NORTHAMPTON
GATEWAY
STRATEGIC RAIL FREIGHT INTERCHANGE

HYDE FARM HOUSE – MINOR SCHEME AMENDMENT

DOCUMENT 8.14

DOCUMENT 8.14 – HYDE FARM HOUSE – MINOR SCHEME AMENDMENT

**REVISIONS TO DESIGN AT  
HYDE FARM HOUSE**

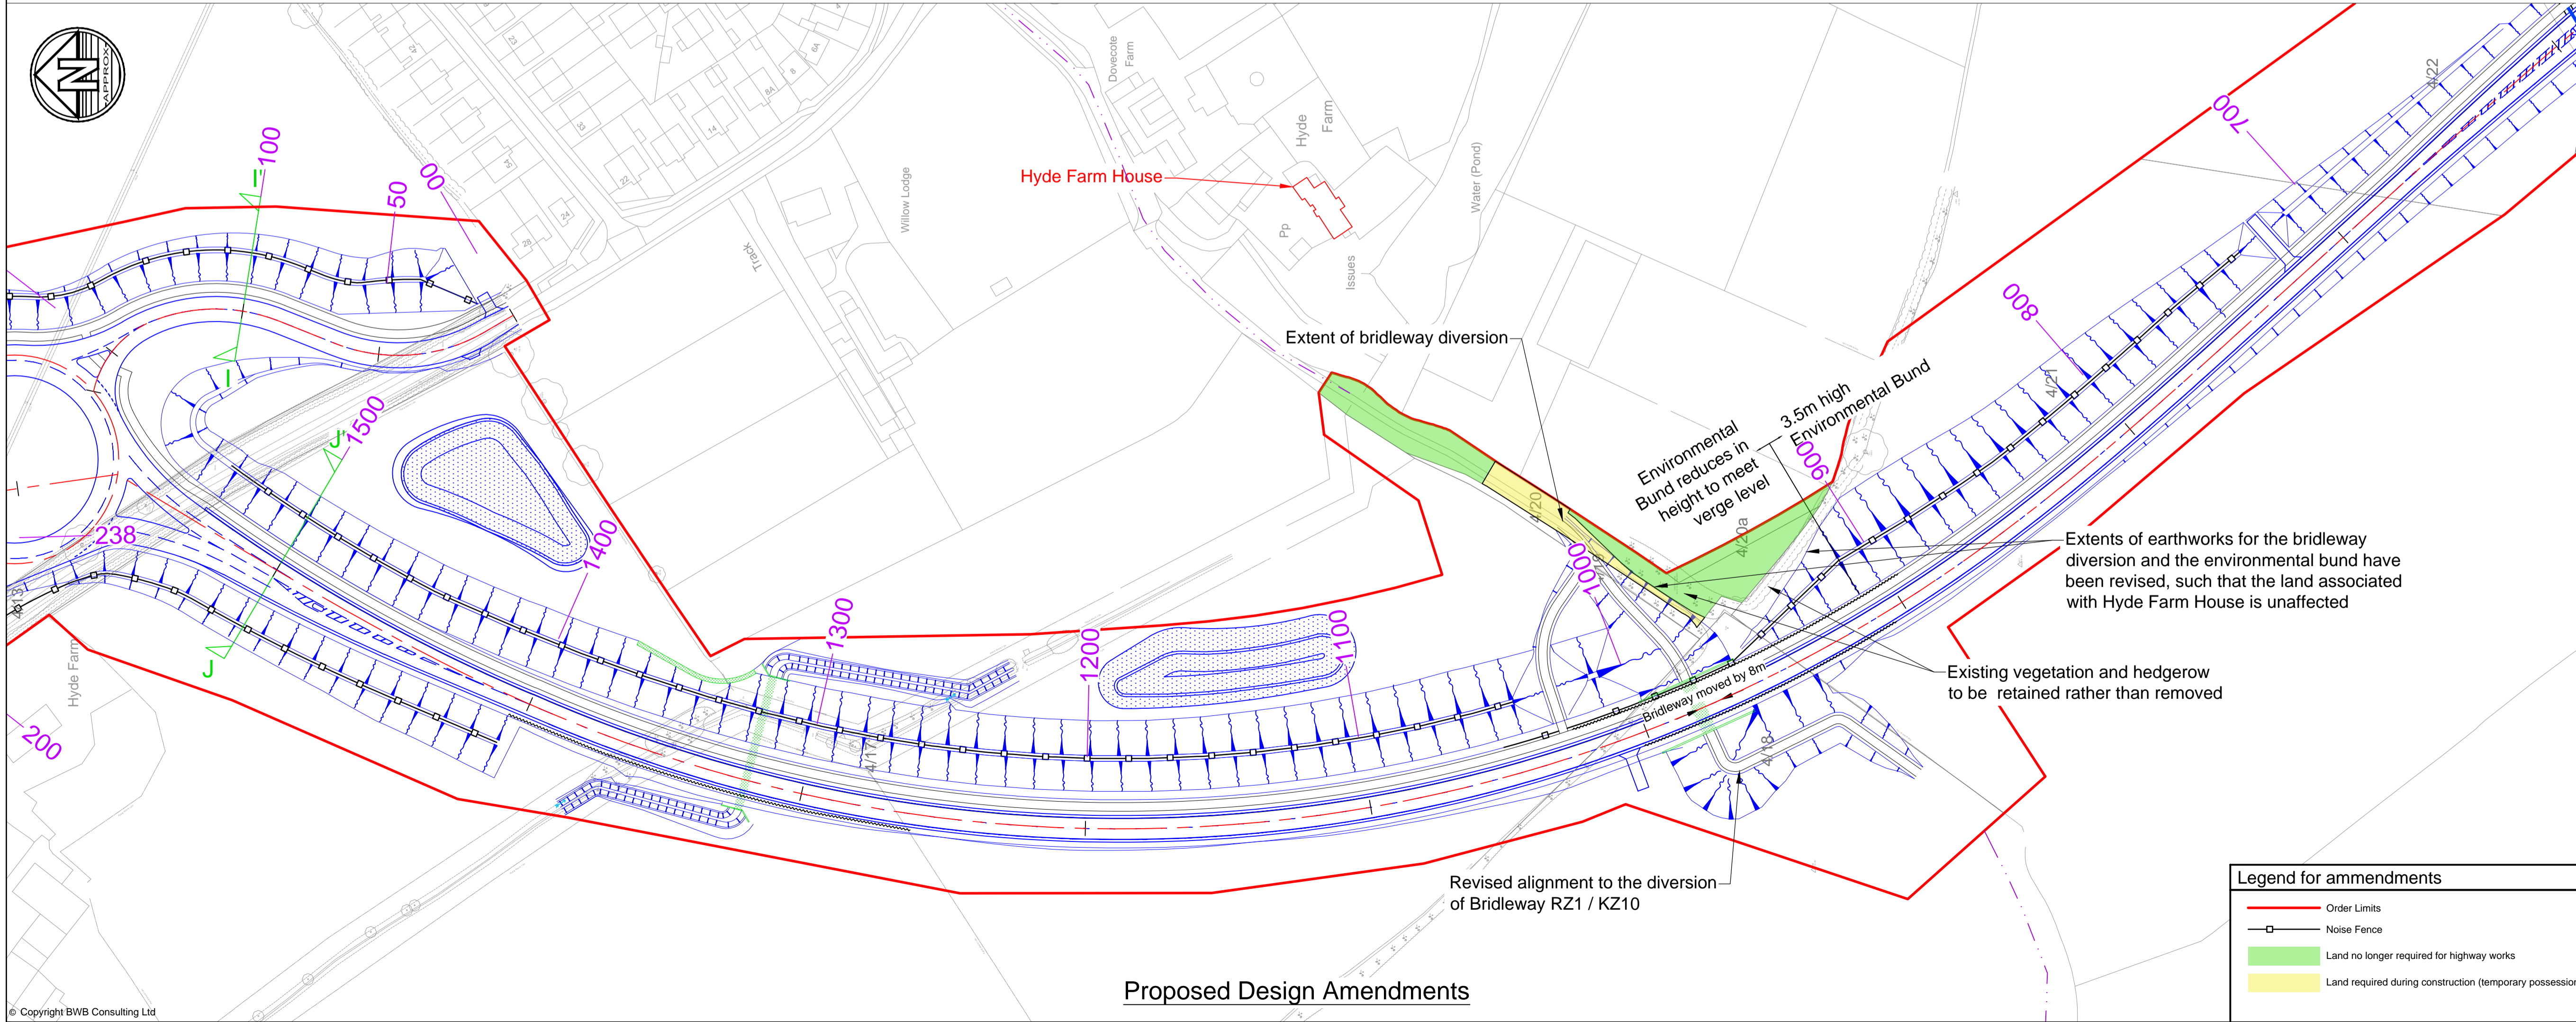
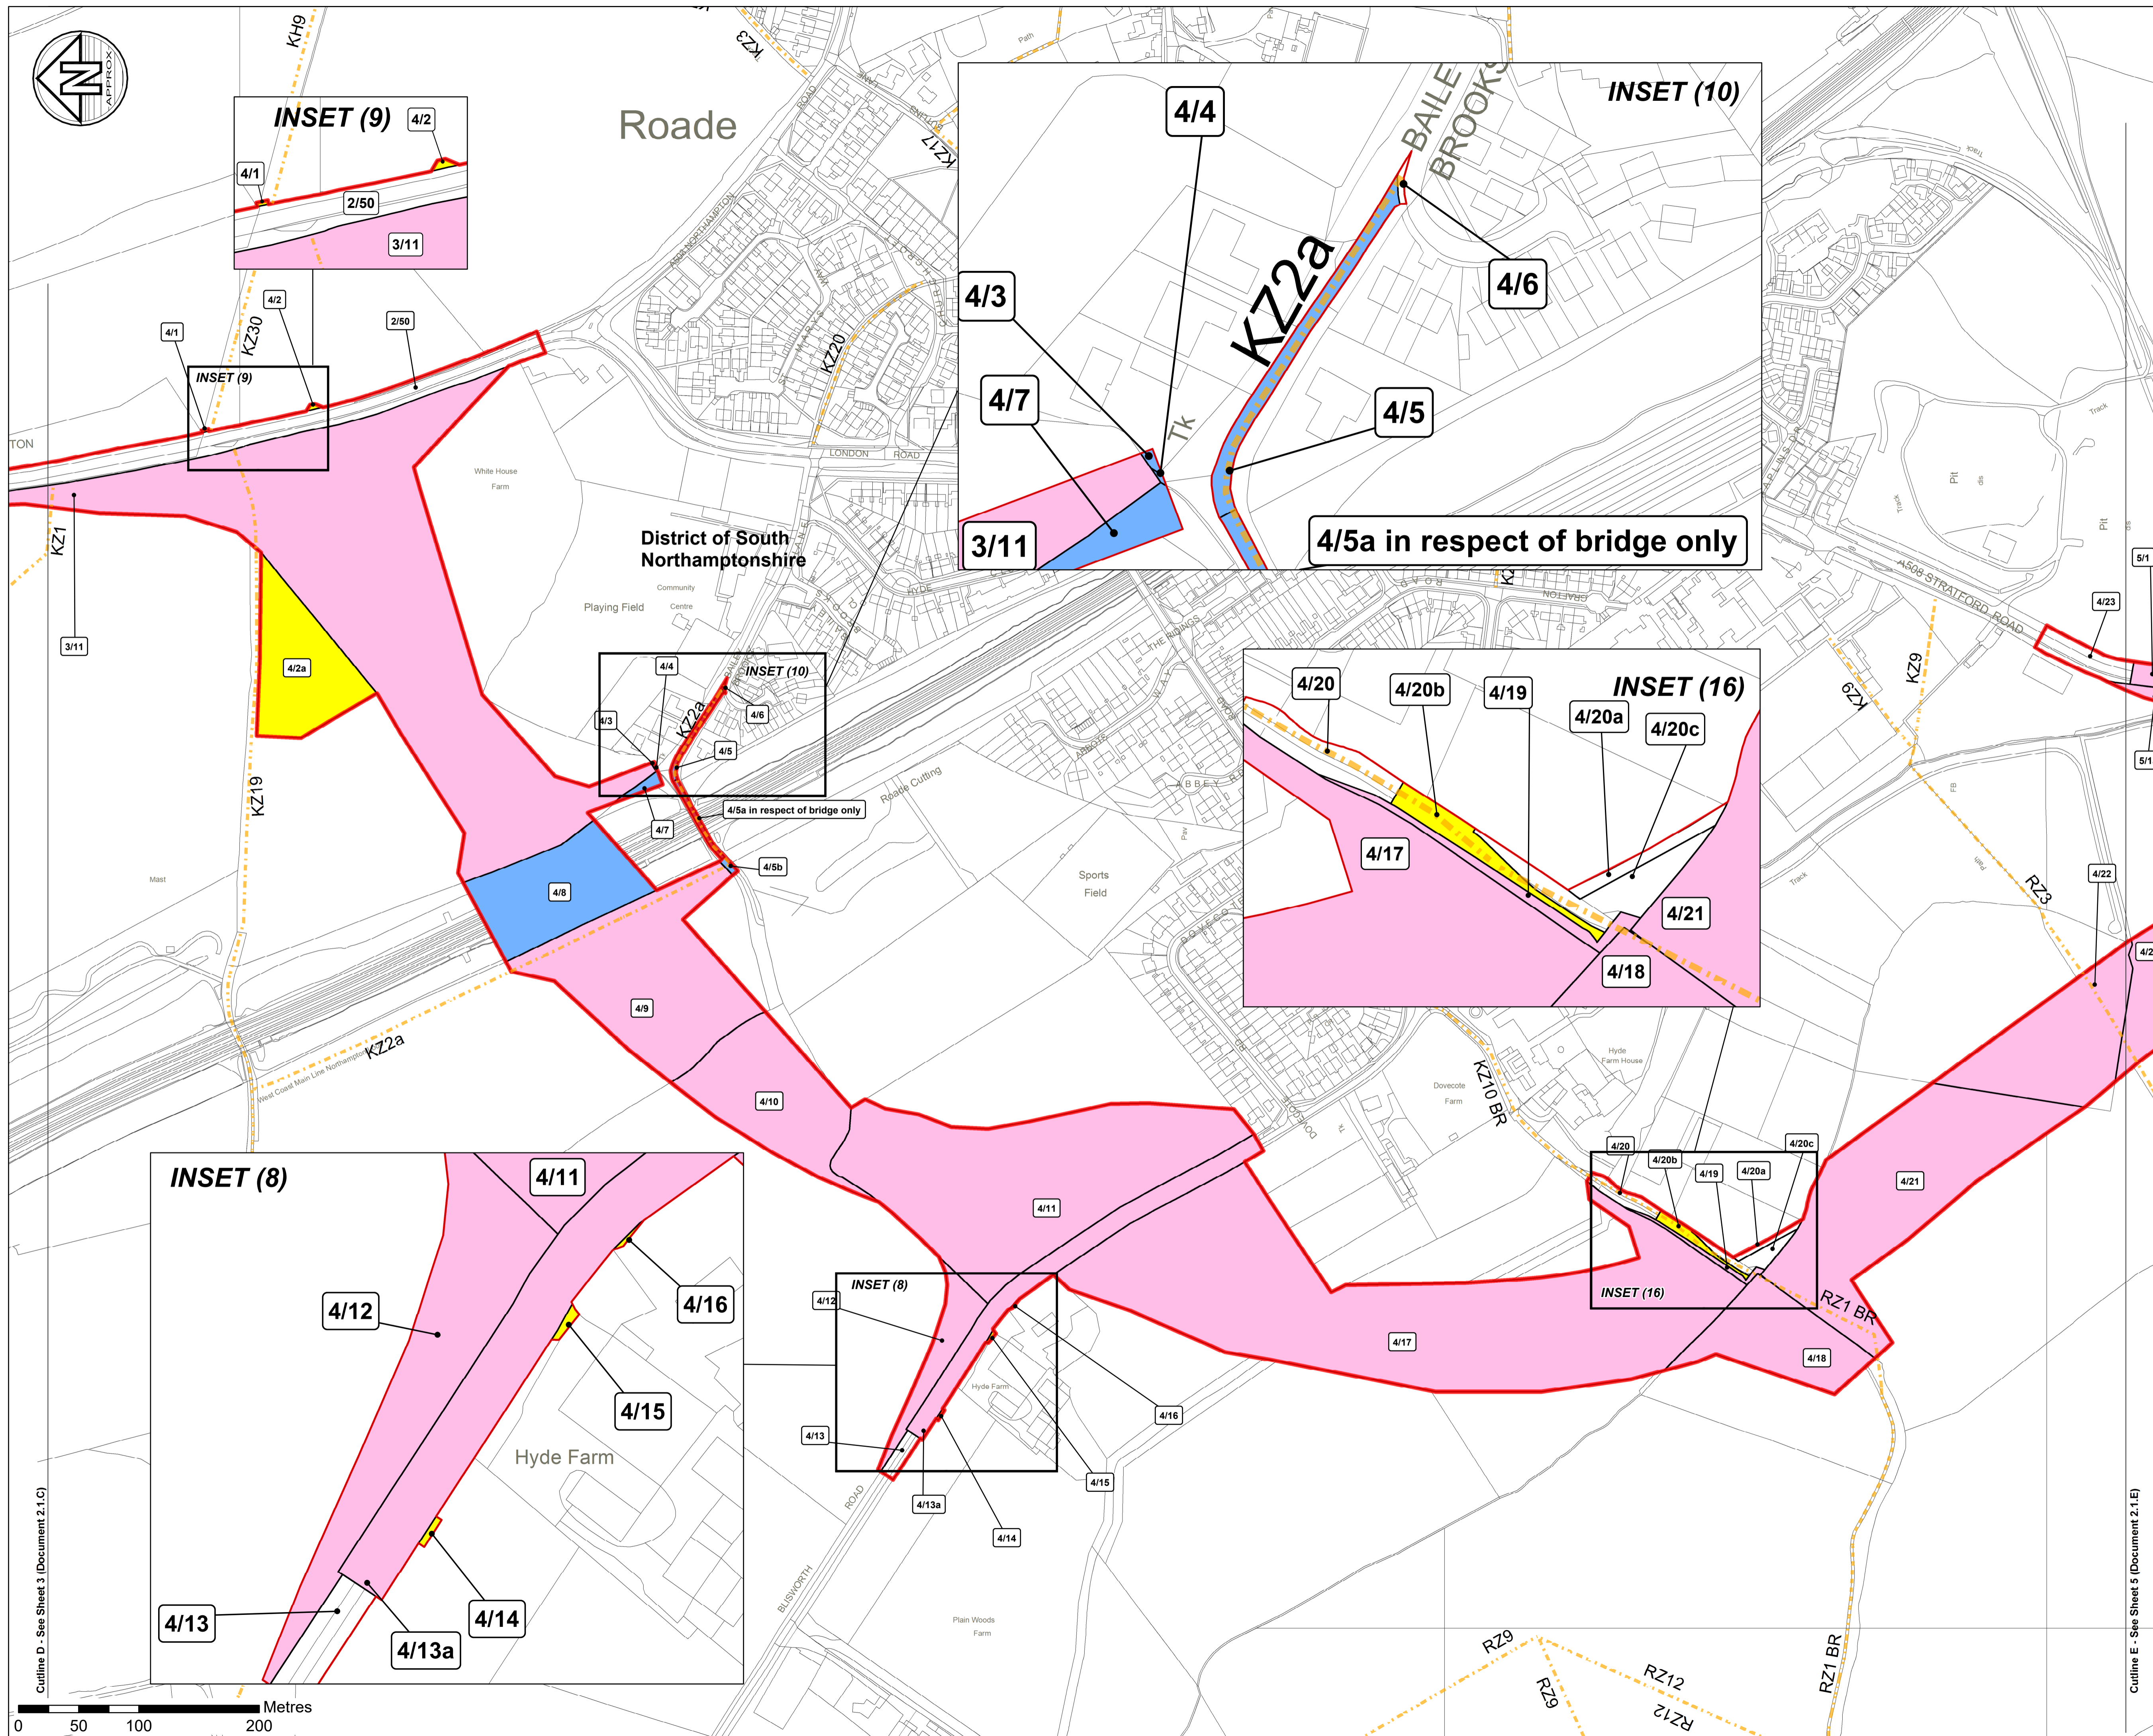
2. The Applicant proposes to relocate the bridleway (KZ10/RZ1) underpass some 8m to the north of its submitted location, and make a minor adjustment to the design of the screening bund adjacent to the bypass. These changes will allow the existing vegetation screening to be retained along the boundary of the land owned by the owners of Hyde Farm House.

3. The changes are shown on the attached drawing (ref NGW-BWB-GEN-XX-SK-C-SK85-S3-P7), which also shows the submitted design for ease of comparison reference. No changes to the geometric design of the bypass itself are proposed.
